**RE: RESPONSE TO ADDITIONAL QUERIES SSD-76555711 – 3-5 HELP STREET, CHATSWOOD**

This letter has been prepared by Mecone on behalf of Loftex Chatswood Pty Ltd (the applicant) in relation to the State Significant Development Application (SSDA) SSD-76555711 for 3-5 Help Street, Chatswood (the site).

EM BE CE

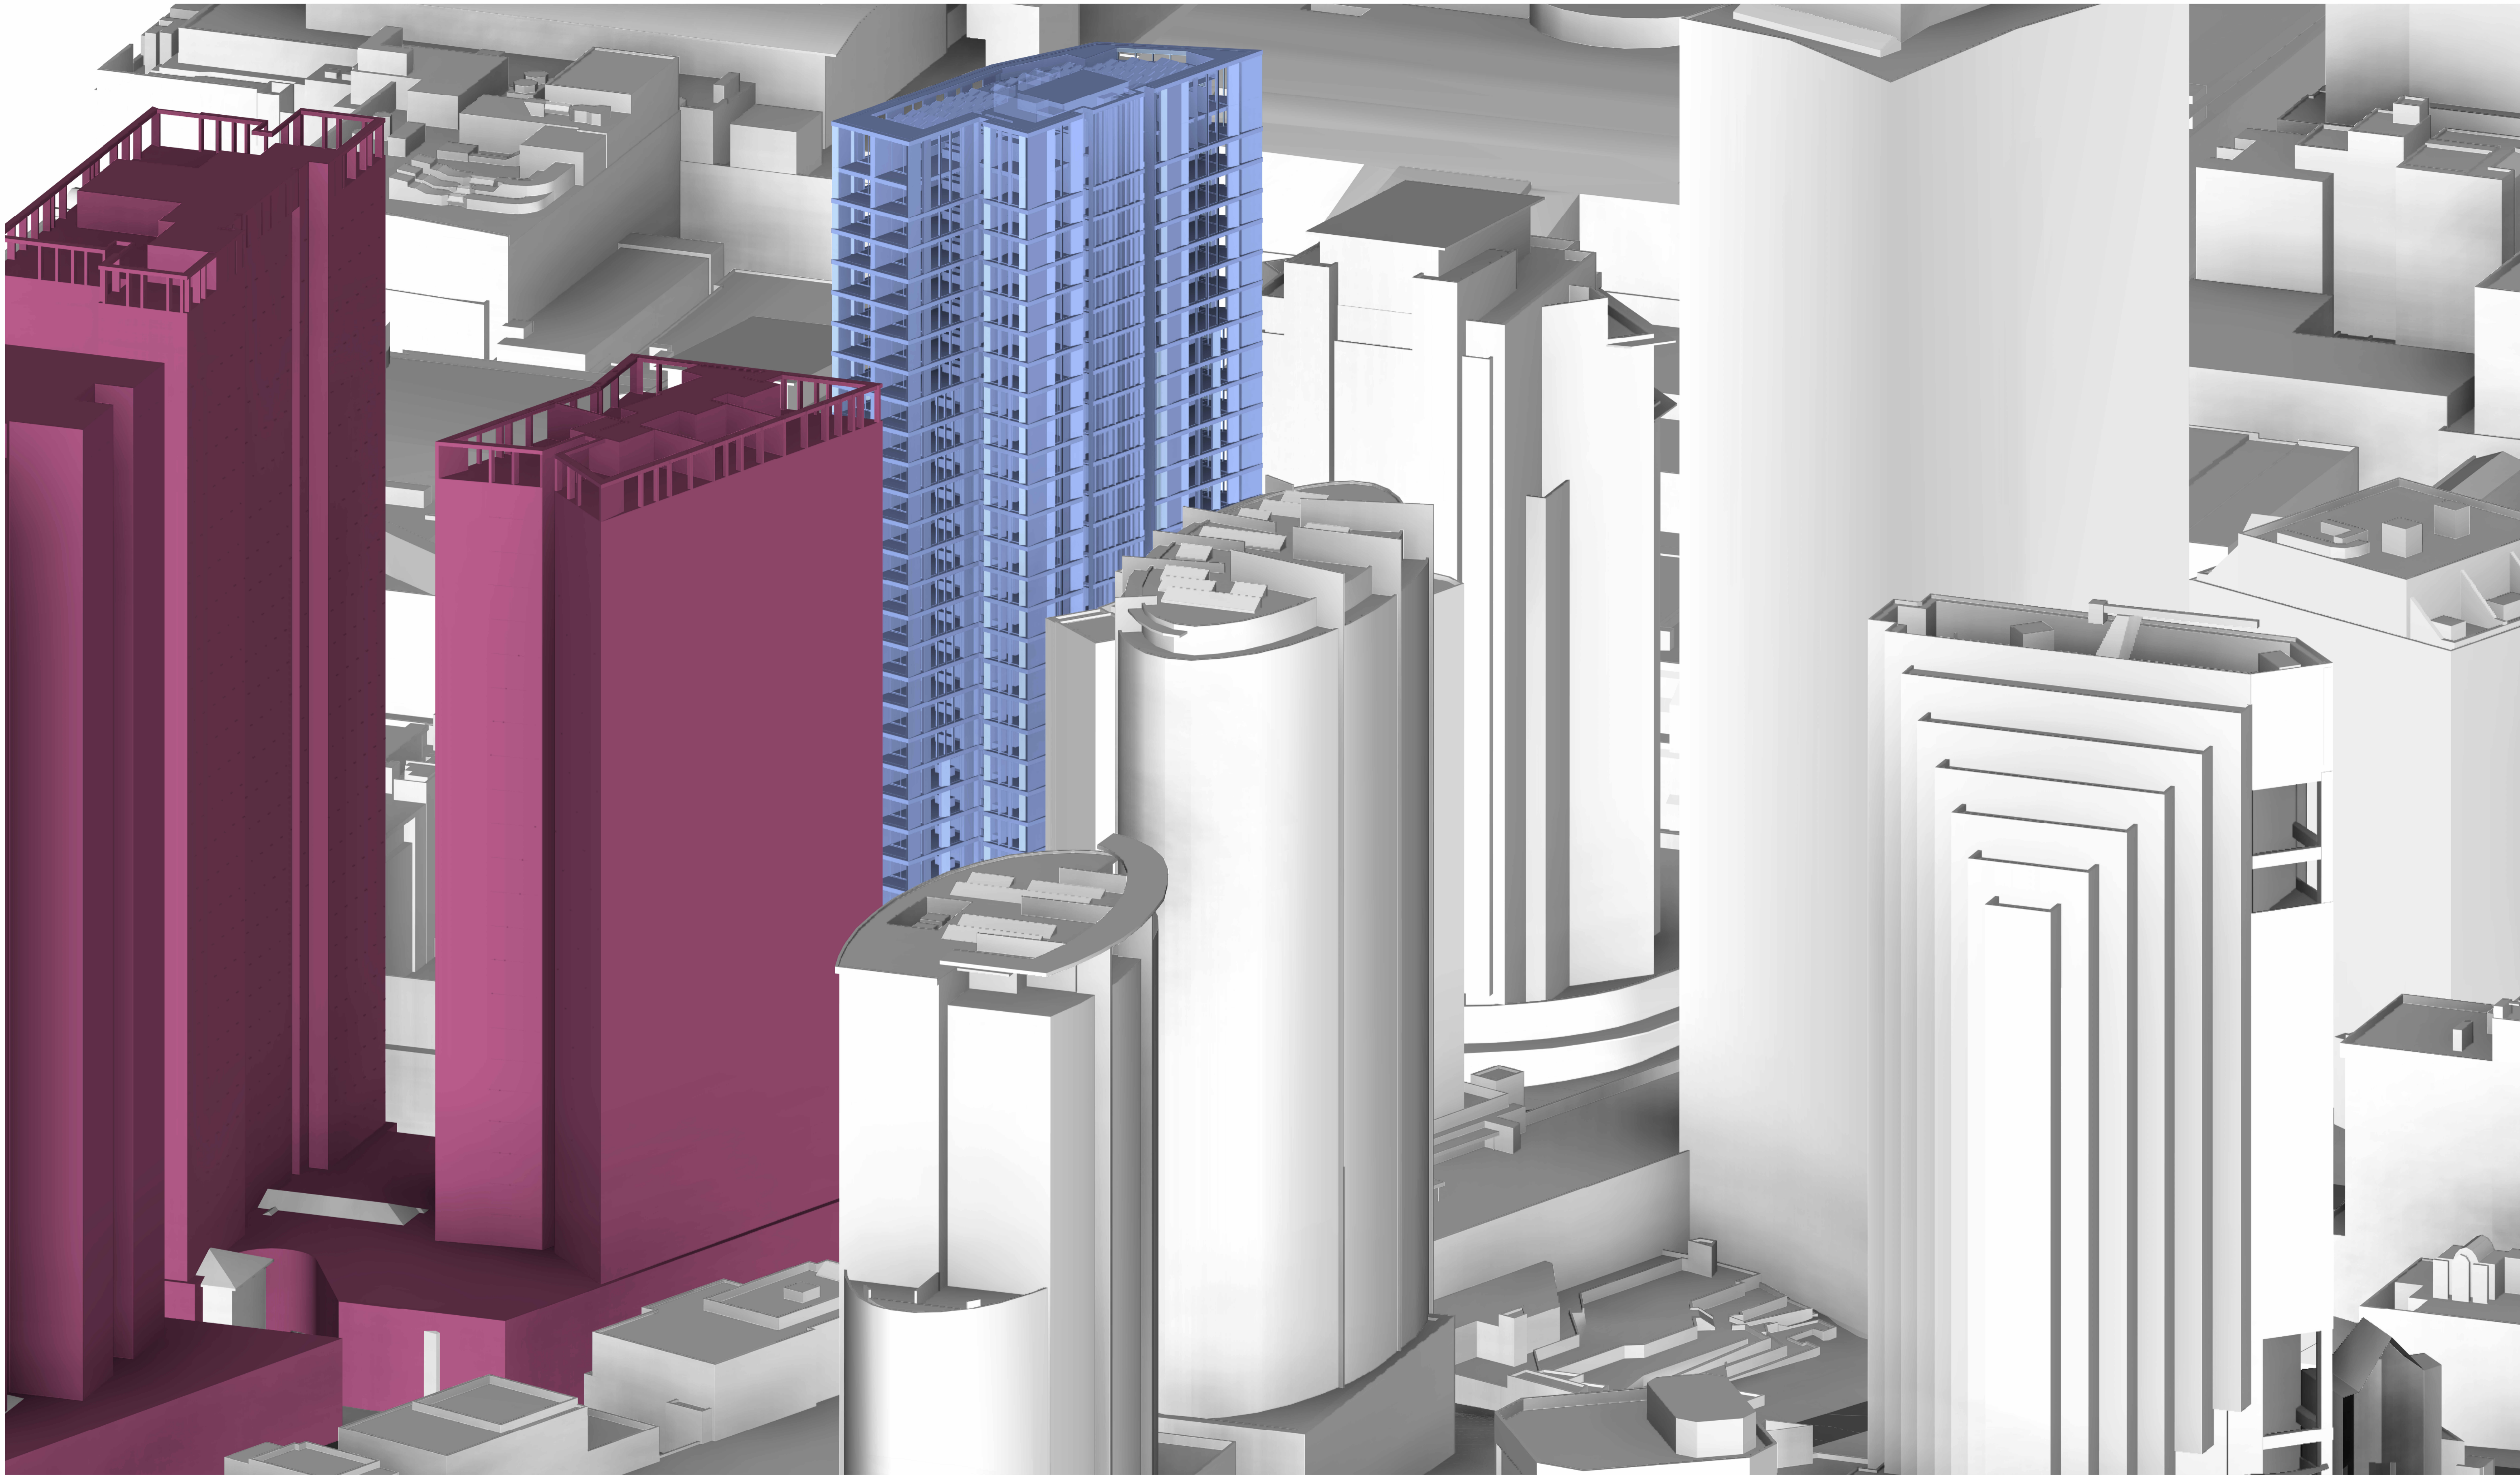
Comment/Query	Response
<b>Solar Access</b>	
<p><b>The following was requested via email from DPHI on 13 October 2025:</b></p> <p><i>The application would benefit from additional solar access data detailing 5–10 minute intervals of sunlight exposure for apartments receiving less than two hours of direct sunlight. This information would strengthen my assessment report by allowing a more thorough discussion of the limitations posed by the proposed northern buildings and demonstrating that the design has maximised solar access to the greatest extent possible.</i></p> <p><b>The following was requested via email from DPHI on 14 October 2025:</b></p> <p><i>Following on from my additional information request yesterday, could you please also supply solar access data from 8am-9am and 3pm-4pm to help justify the site not meeting the ADG sunlight requirements?</i></p>	<p>As requested, the updated View from the Sun Diagrams have been provided at <b>Attachment 1</b> and <b>Attachment 2</b>, showing the solar access to the building façade in 15-minute increments from 8am to 4pm.</p> <p>A detailed statement addressing solar impact has been provided by EMBECE at <b>Attachment 3</b>. In summary, if the proposed SSDA to the north of the site is approved in its current form, with the consideration of extended solar access hours to include 8am-9am and 3pm-4pm, then at least 119 of 166 apartments (74%) will receive 2 hours of sunlight to either the habitable rooms or private open space between the hours of 8am to 4pm on June 21,.</p> <p>Noting that 74% of apartments will still have access to sunlight in mid-winter, despite the proposed SSDA to the north, is evidence that the proposal can satisfy the objectives of Part 4A-1 of the ADG.</p> <p>A detailed summary of how the design achieves compliance with the objectives of Part 4A-1 of the ADG is provided in <b>Attachment 3</b>.</p>
